November 22, 2019

RE: *Green Mountain Falls County Documents Review Comments and Redlines*

Thank you for the comments on November 18, 2019 for the above-mentioned project. In an effort to address your comments concisely and simplify your review process, we have summarized your comments and our responses below.

REV: 11/22/19
REV: 10/18/19
PROPOSED DRAINAGE PLAN
SHEET 2 OF 3

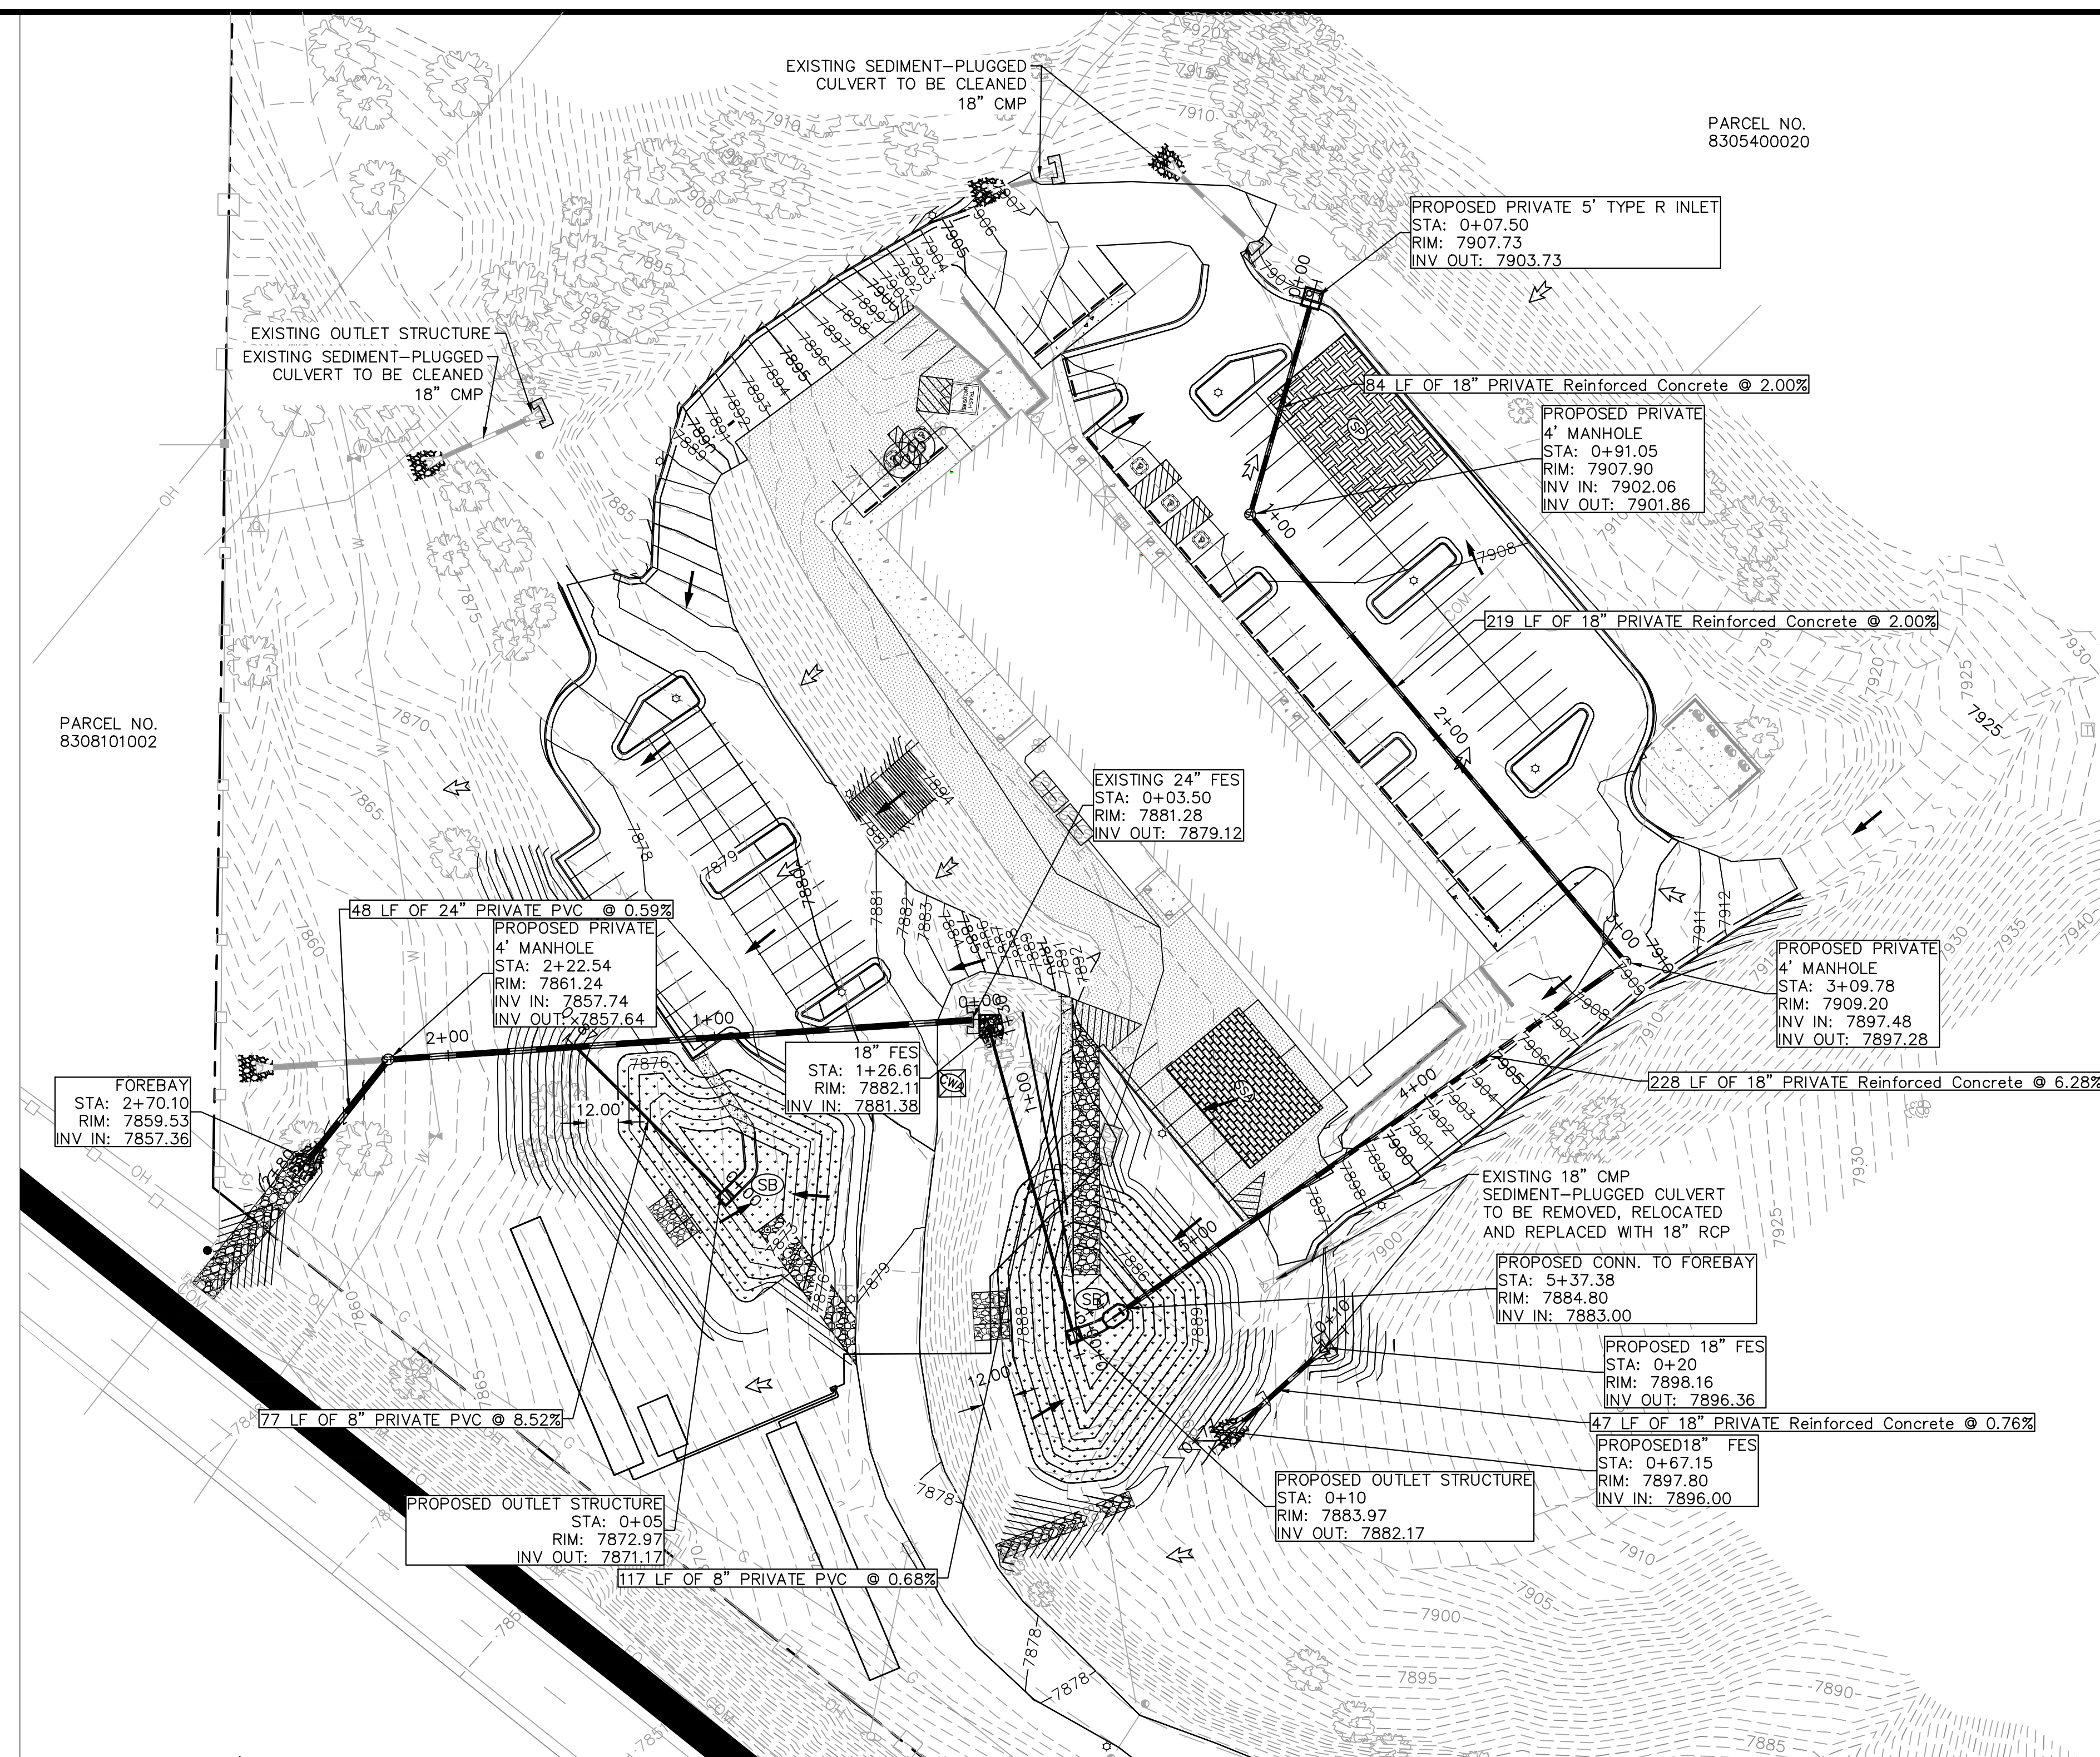
Response: Protection has been added at the outfall in reference.
10. Please label the existing culvert.
Response: Culvert in reference has been labeled.
11. Fix arrow so that it is pointing to the notch.
